Recommendation Report for Planning Permission for Works or Extension to a Dwelling

REF NO: AW/272/21/HH

LOCATION: 73 Marlborough Court
Bognor Regis
PO21 5QJ

PROPOSAL: Single storey rear extension and conversion of garage to kitchen

Drawing No.
3 (22) 00

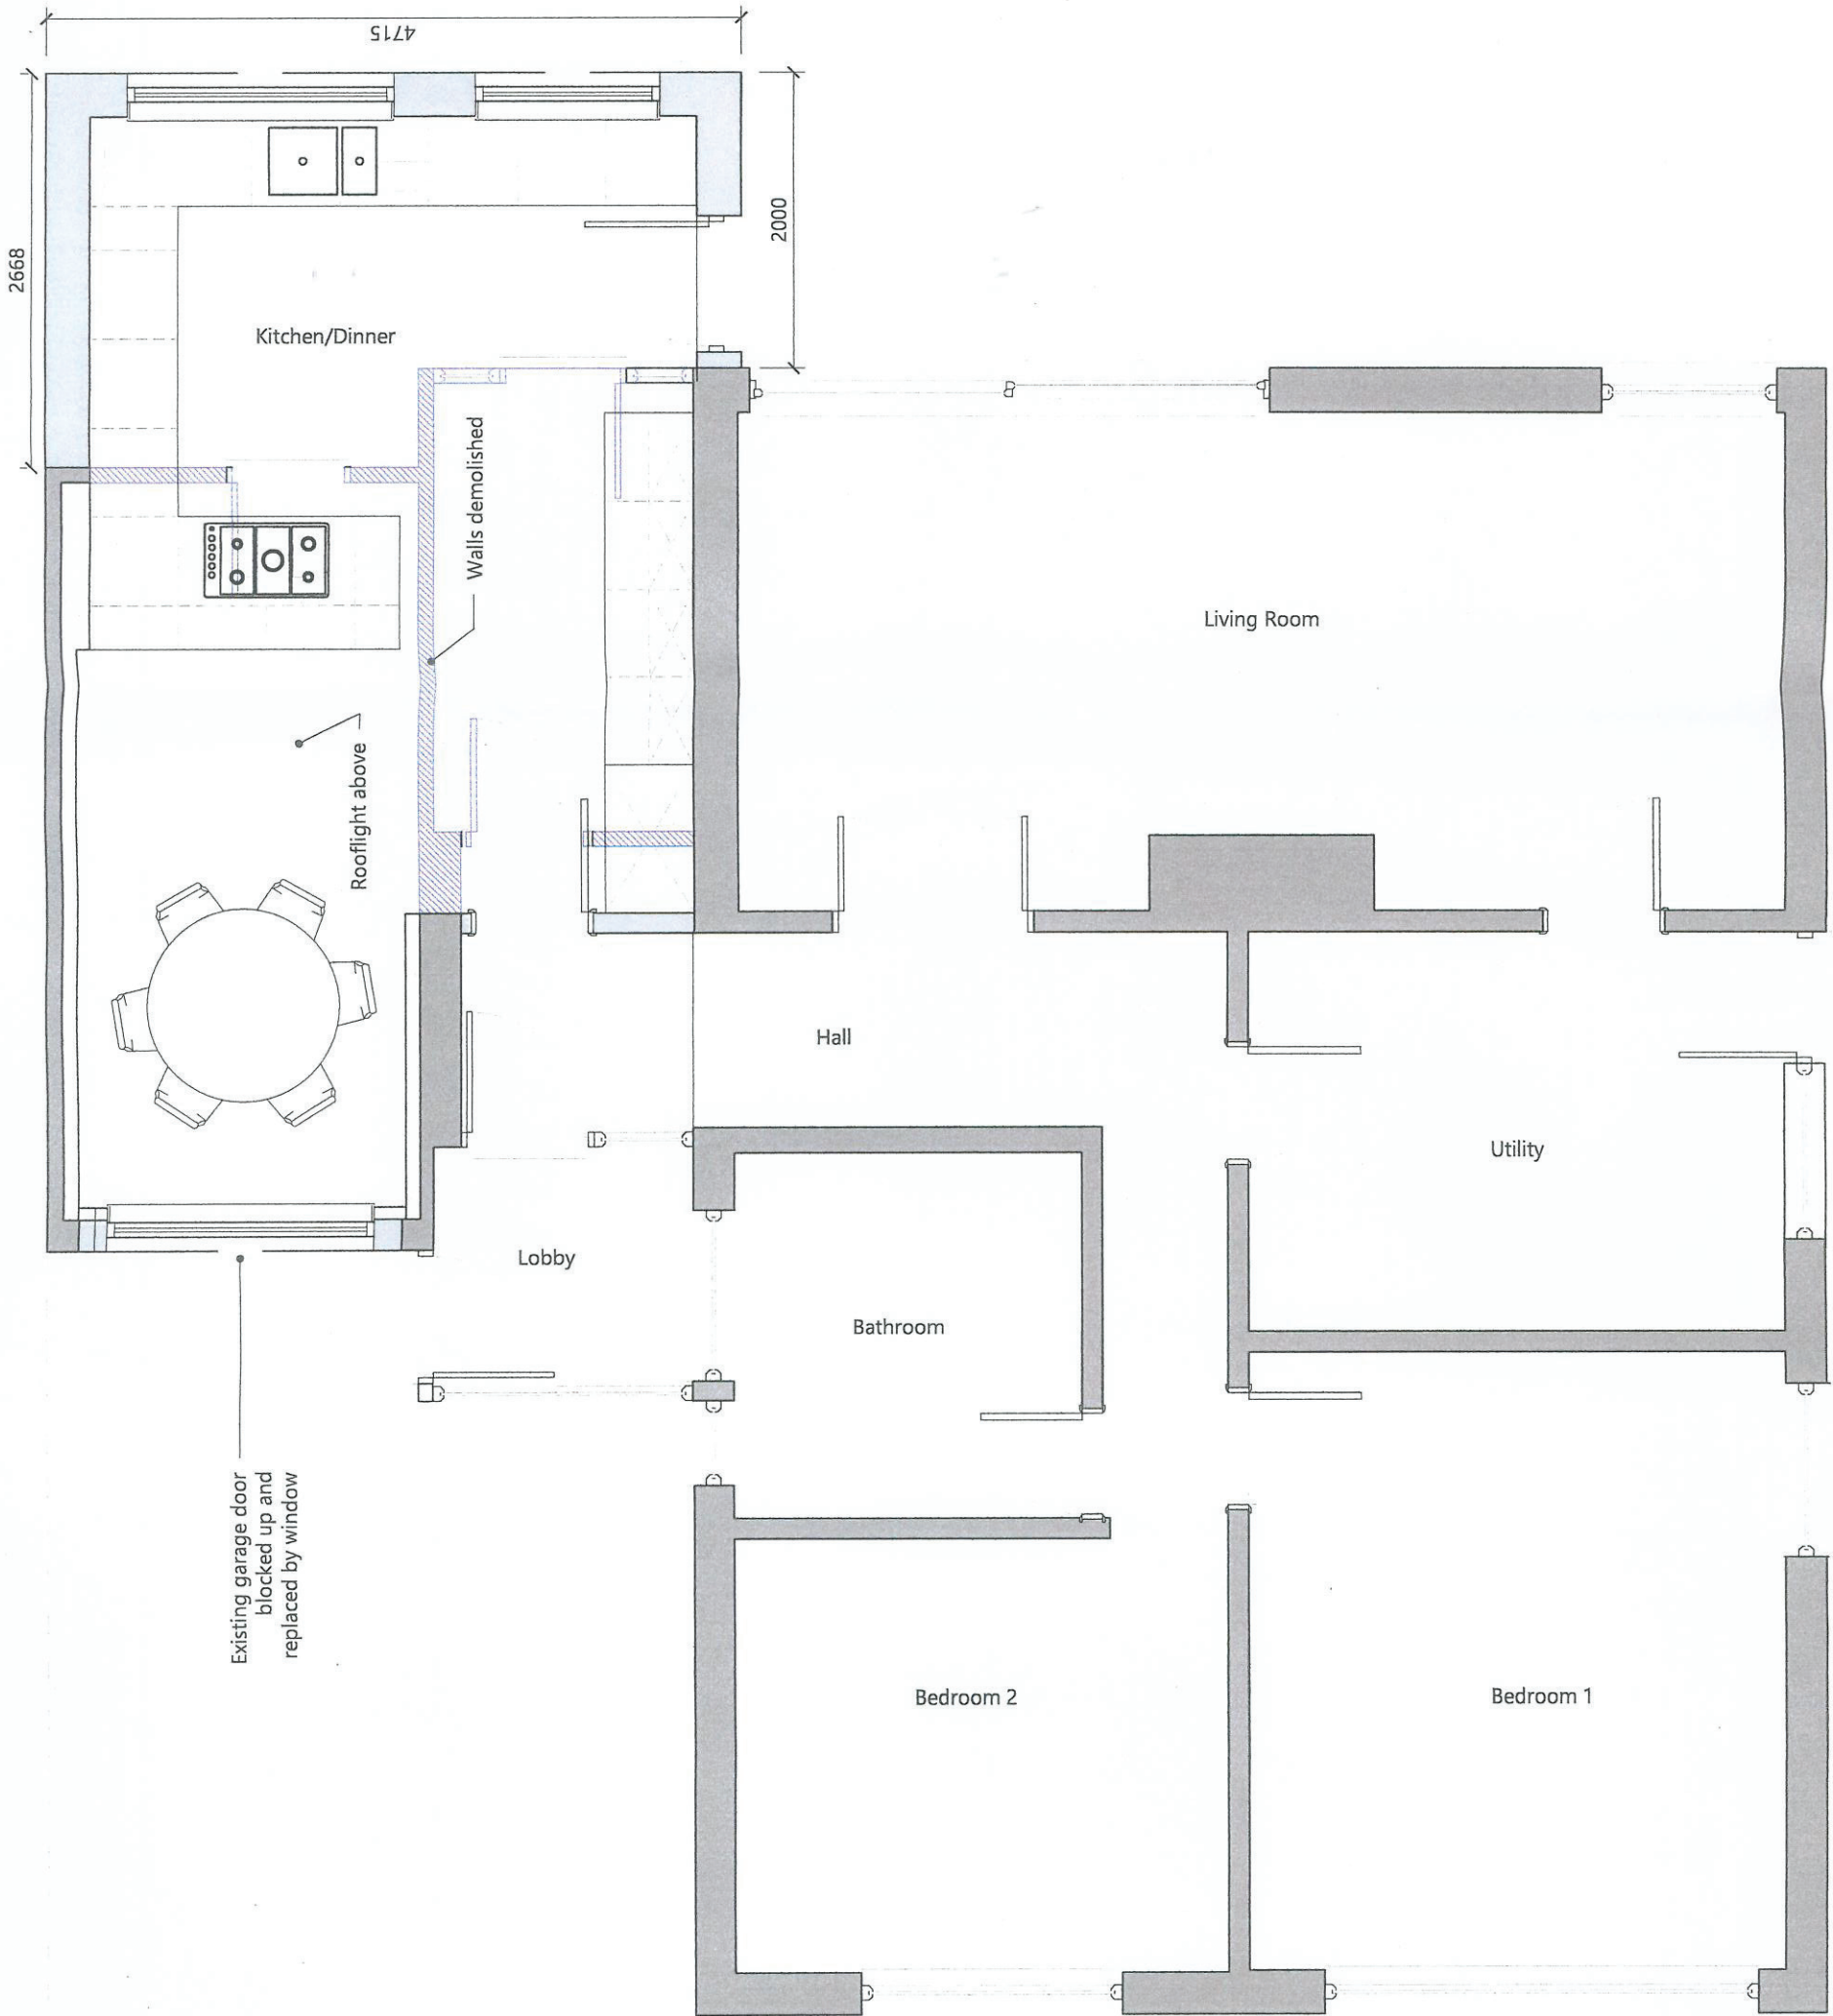
The conversion of garage to kitchen will contain one new window (3 window panes) to front (north west) and one new rooflight to side (north east) roof plane.

3 (10) 01

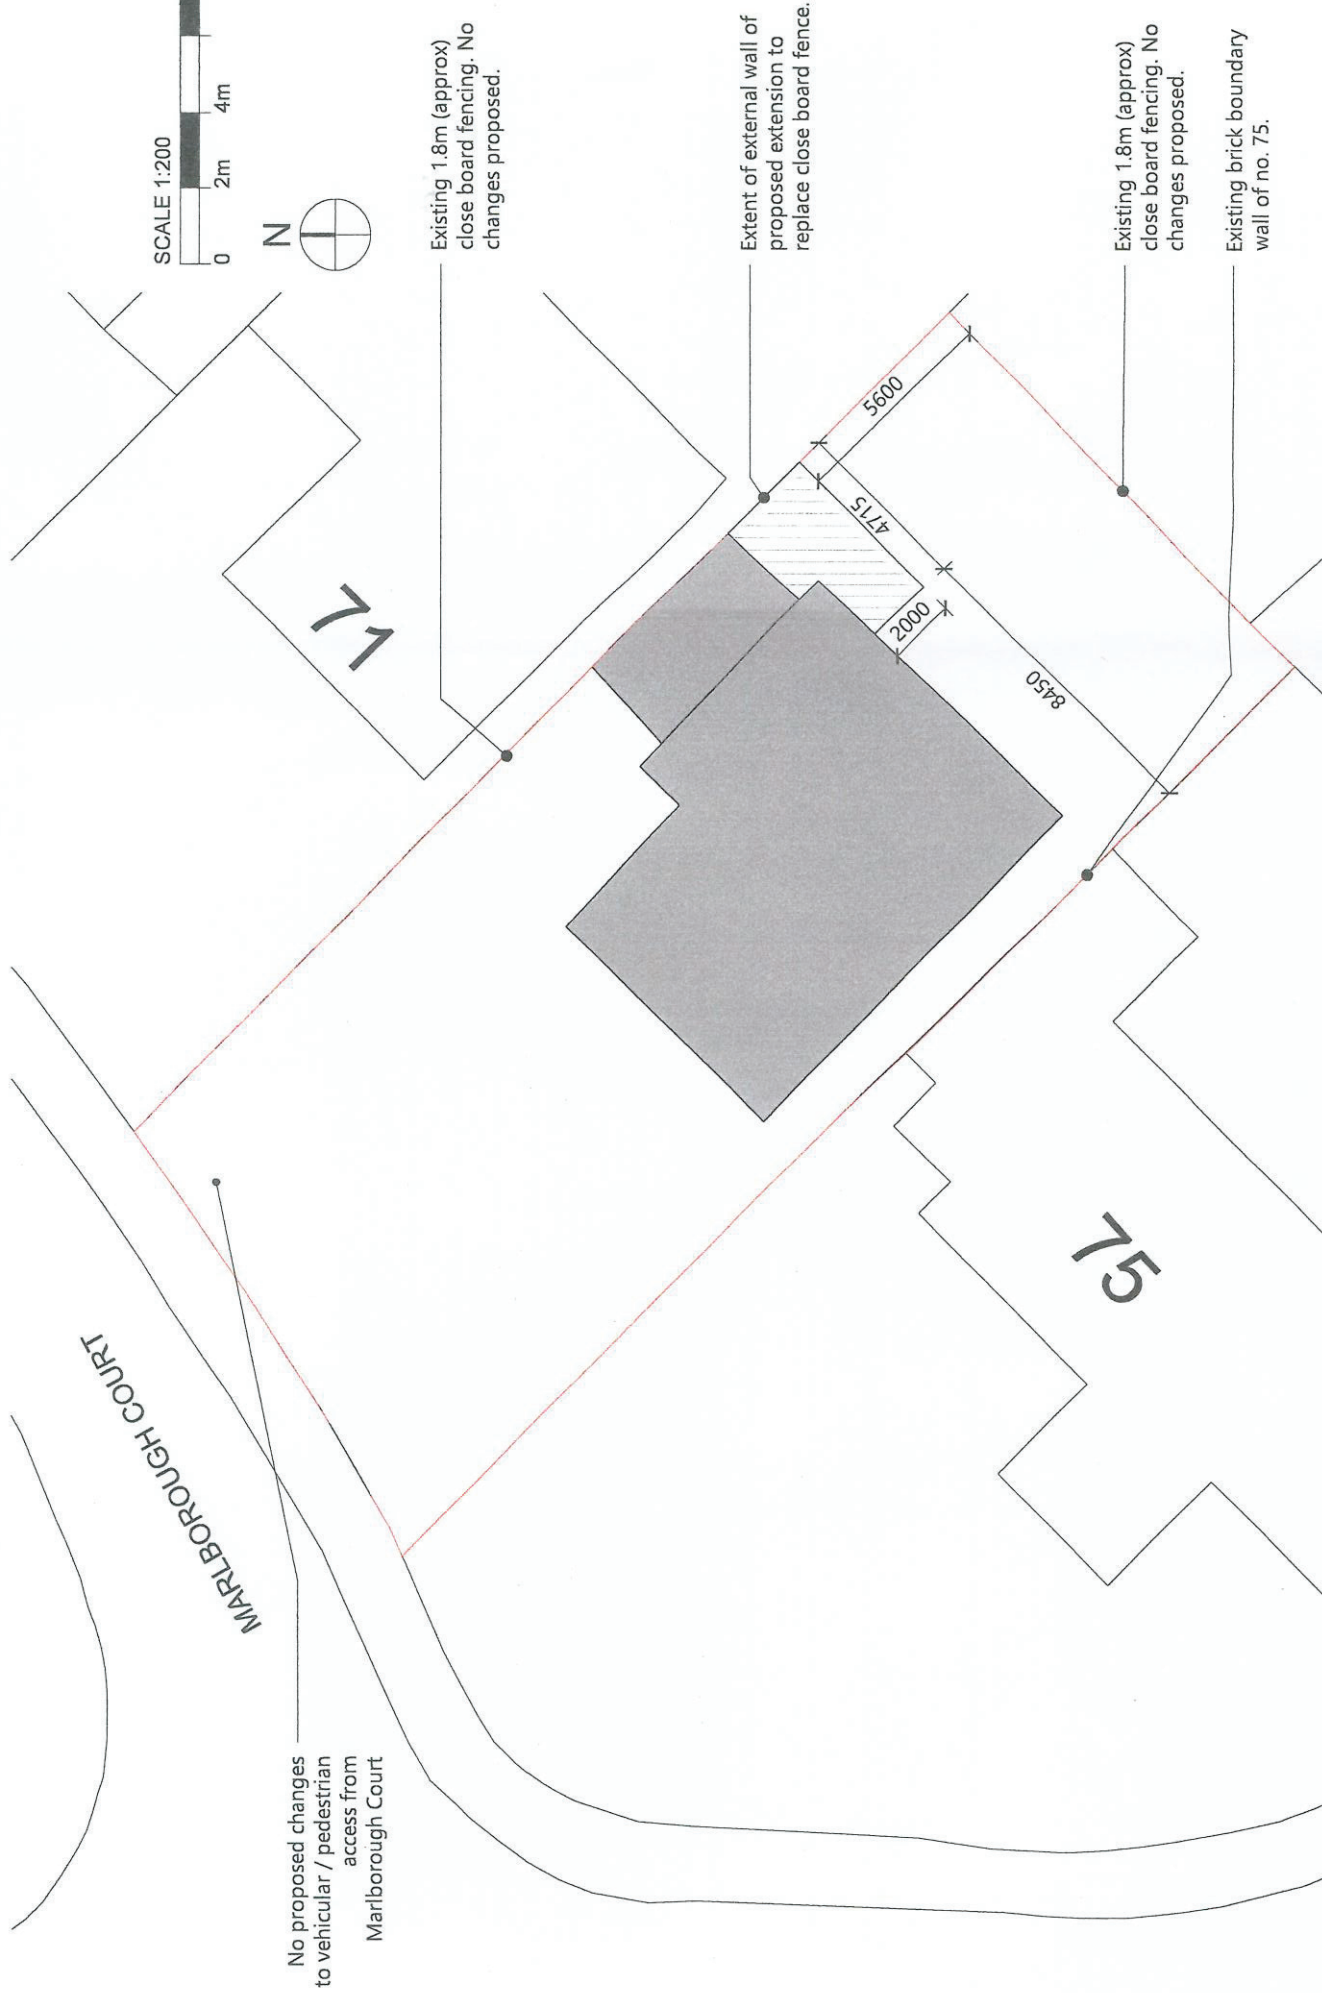
Due to loss of existing garage there will be reduced parking availability however due to driveway of around 17.37m retained to front 2 spaces still seem to be available so complies with policy T SP1 and Arun Parking Standards.

Due to 5.6m retained to rear (south east) boundary there is no adverse harm to overlooking to rear properties.
